CITY OF ALBUQUERQUE

April 24, 2019

**RE: Catalonia Subdivision
Tr 1 & 2, The Trails Unit 3A
Drainage Report Stamp Date: 3/29/19
Grading Plan Stamp Date: 3/29/19
Hydrology File: C09D013**

CITY OF ALBUQUERQUE DEPARTMENT OF MUNICIPAL DEVELOPMENT	
CATALONIA GRADING PLAN			
DESIGN REVIEW COMMITTEE	CITY ENGINEER APPROVAL	MO./DAY/YR.	MO./DAY/YR.
LAST DESIGN UPDATE			
CITY PROJECT NO.	ZONE MAP NO. C-08	SHEET 2	OF

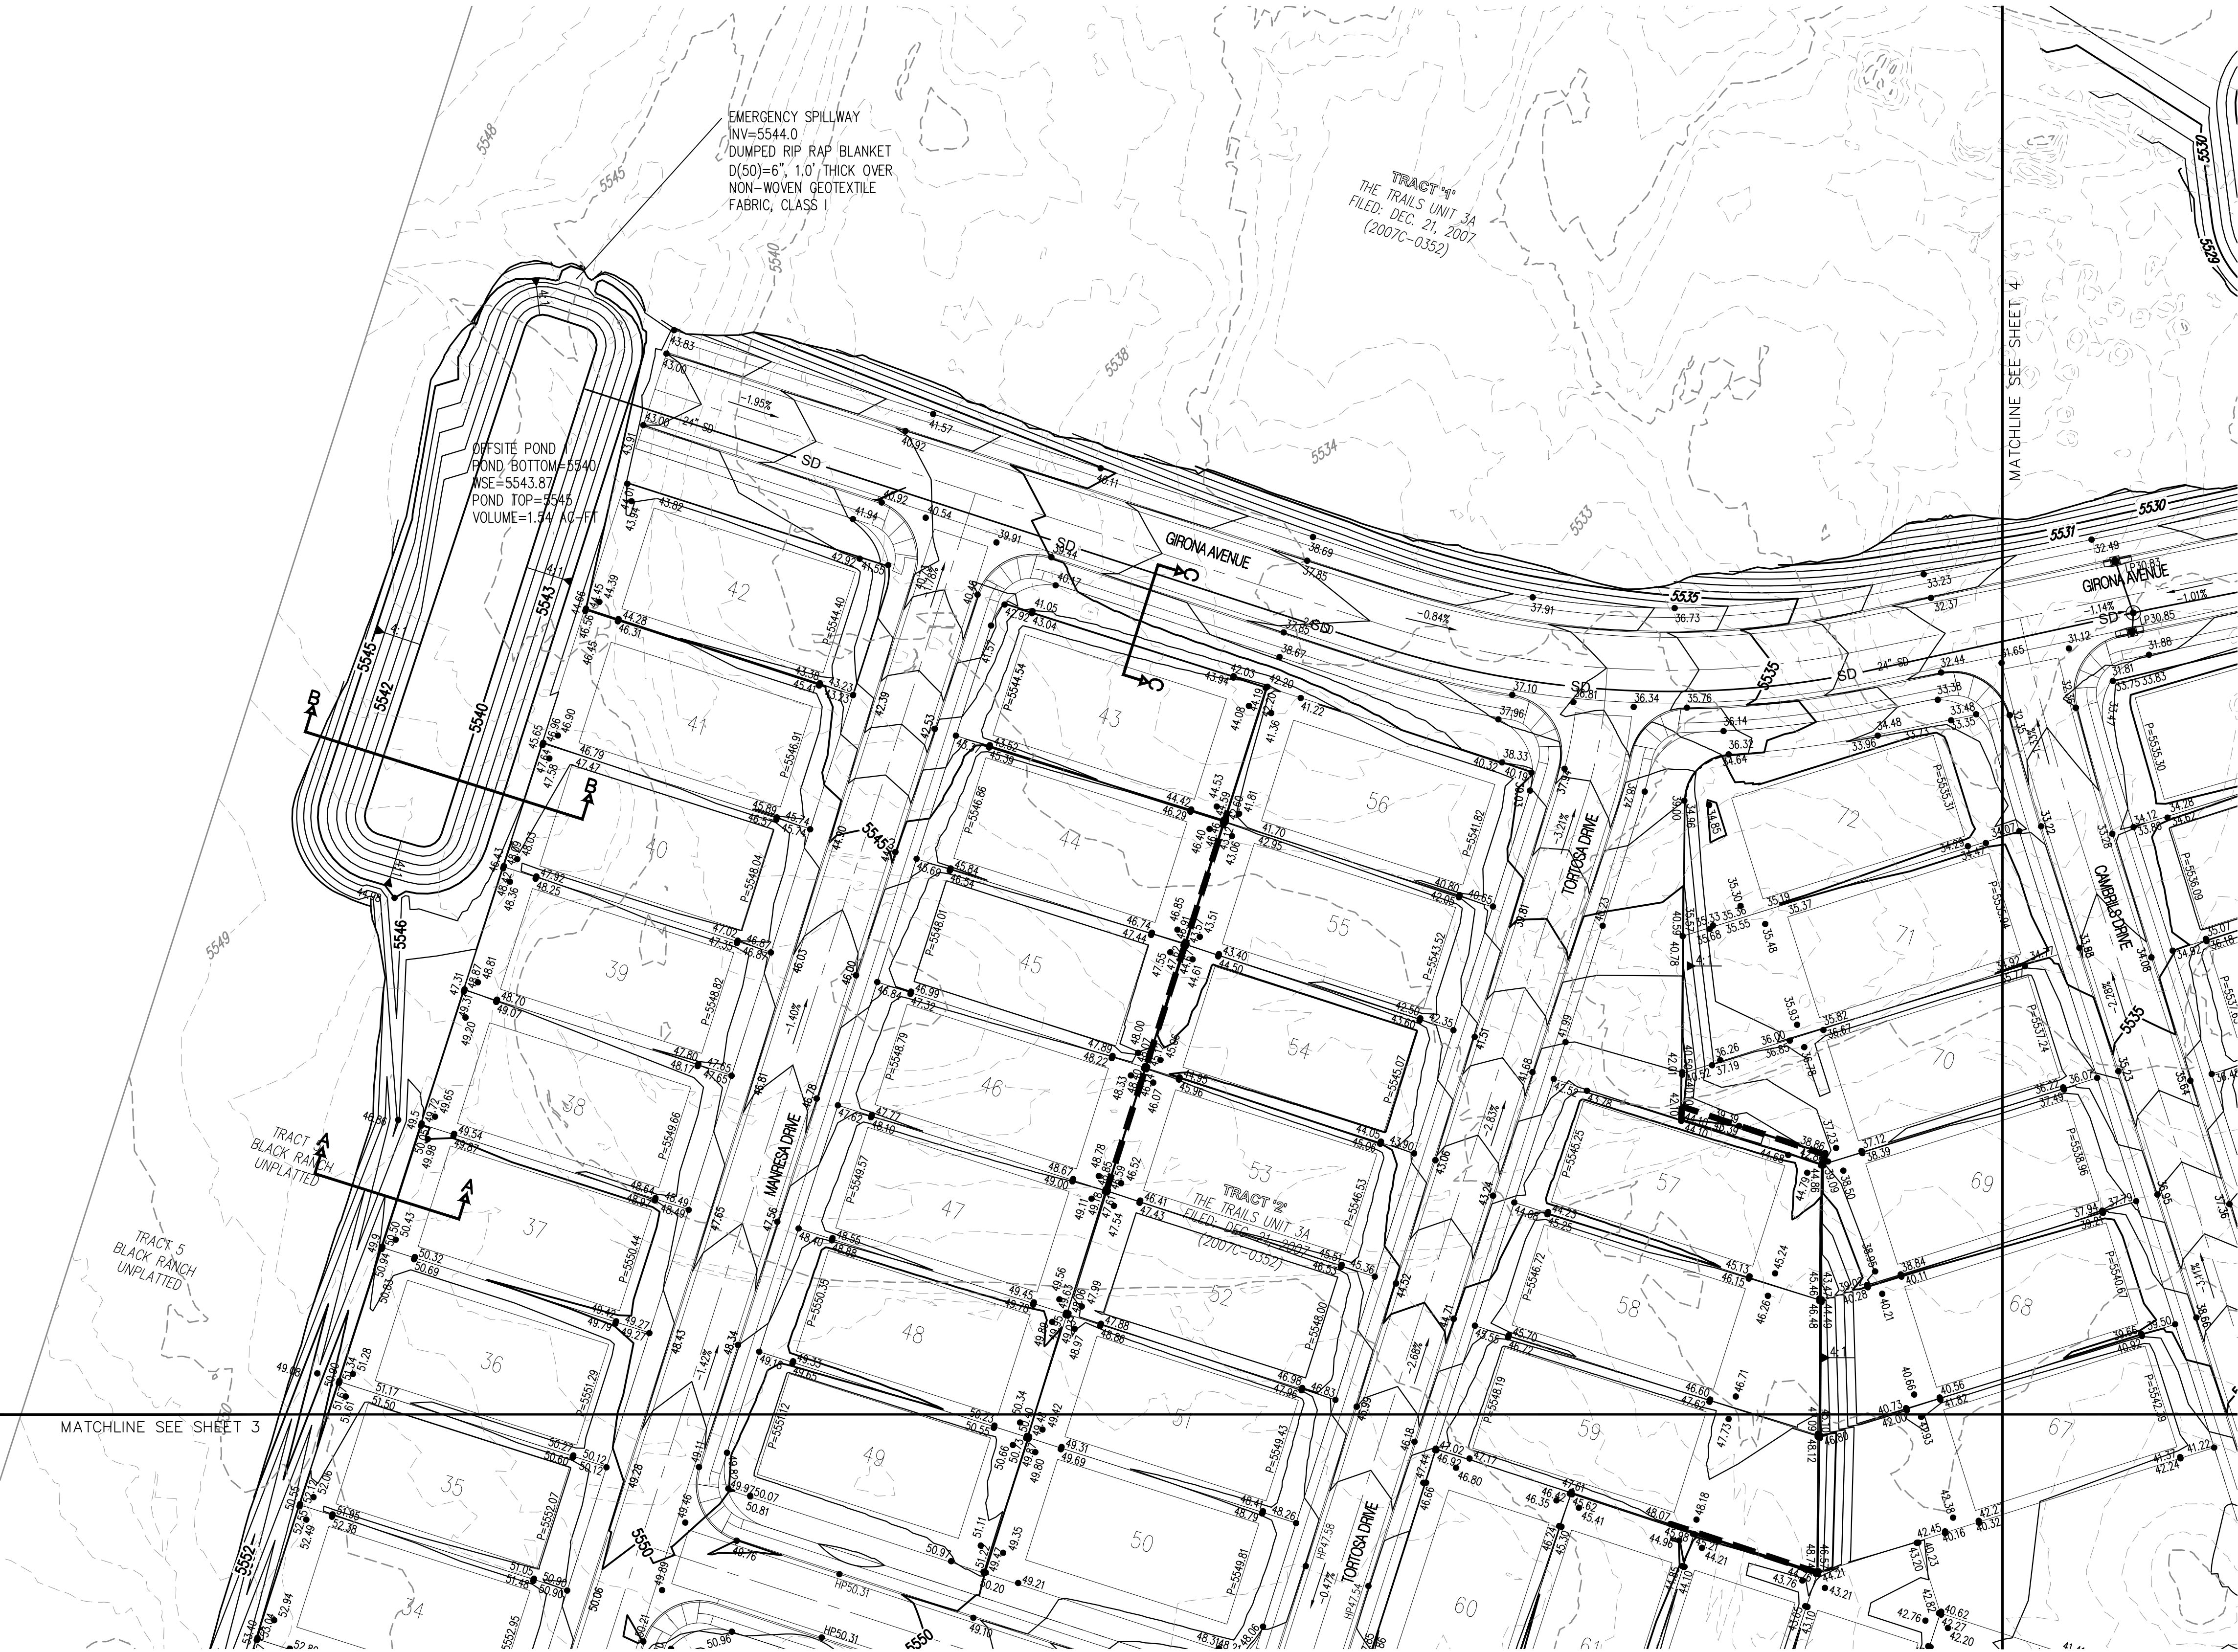
- i. Show and label the 100-yr WSE and SWQV elevation of each pond on the grading plan.
6. Storm Water Quality. Appendix E.
 - a. The storm water quality volume (SWQV) contained in Temporary Pond 1 and Woodmont Temp Pond is not acceptable, as these ponds are presented as temporary facilities that will go away once the downstream pipe is built. Provide a permanent SWQ facility to store the SWQV from Basin A and Offsite Basin 2.

10. Grading Plan Remarks.
 - a. Sheet labeling shown on Sheet 1 is incorrect.
 - b. Do not grade on Lot 9-16, Valle Prado Unit 5.
 - c. Add a line type to the legend for *Retaining Wall, Constructed Prior to Grading/Pad Certification*. These are for the side lot retaining walls to be built by the grading contractor.

- d. Provide grate (or LP) elevation at IN2 and IN3. Ensure that there is an adequate sump between these inlets and the waterblock for Woodmont & Girona, so high flows don't simply spill over to Woodmont. This high point elevation also needs to be called out.
